TRANSPORT FOR LONDON

M25 JUNCTION 28 IMPROVEMENTS – DEADLINE 6 SUBMISSION

27 APRIL 2021

- I.1 This document provides TfL's comments on responses to the Examining Authority's (ExA's) Further Written Questions (WQ2) and any other documents submitted by the Applicant and Interested Parties at Deadline 5. Section 2 of this document covers the Further Written Questions, Section 3 addresses the Applicant's response to TfL's written summary of the hearings, while Section 4 provides comments on the updated draft DCO submitted at Deadline 5.

**Fig 3.1 - HE Indicative alignment of amended Grove Farm egress (Change 8)**

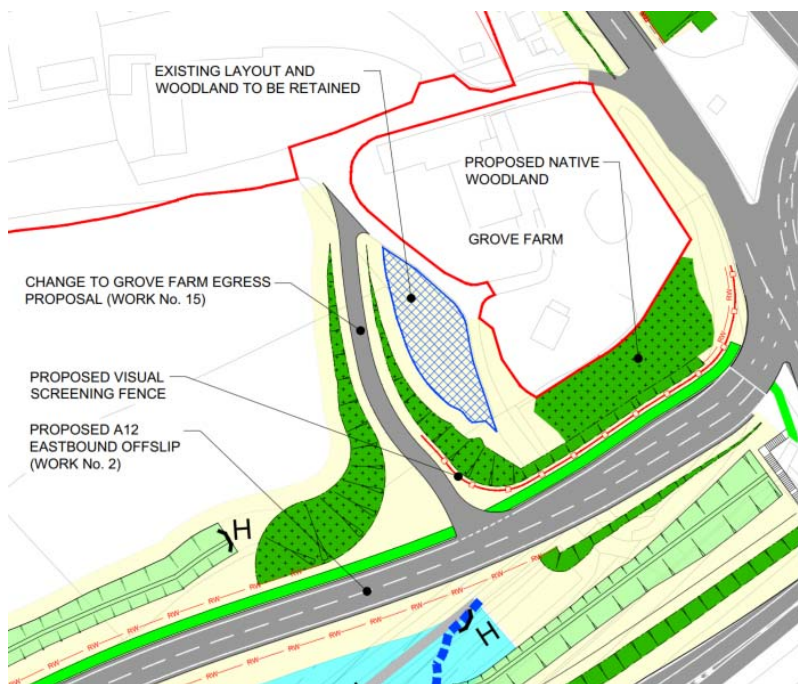
- 2.15 TfL notes that an alternative egress route from Grove Farm onto the proposed new A12 eastbound off slip has been put forward as Change Request 8. TfL will review this proposal and respond to the Applicant’s consultation on this matter.
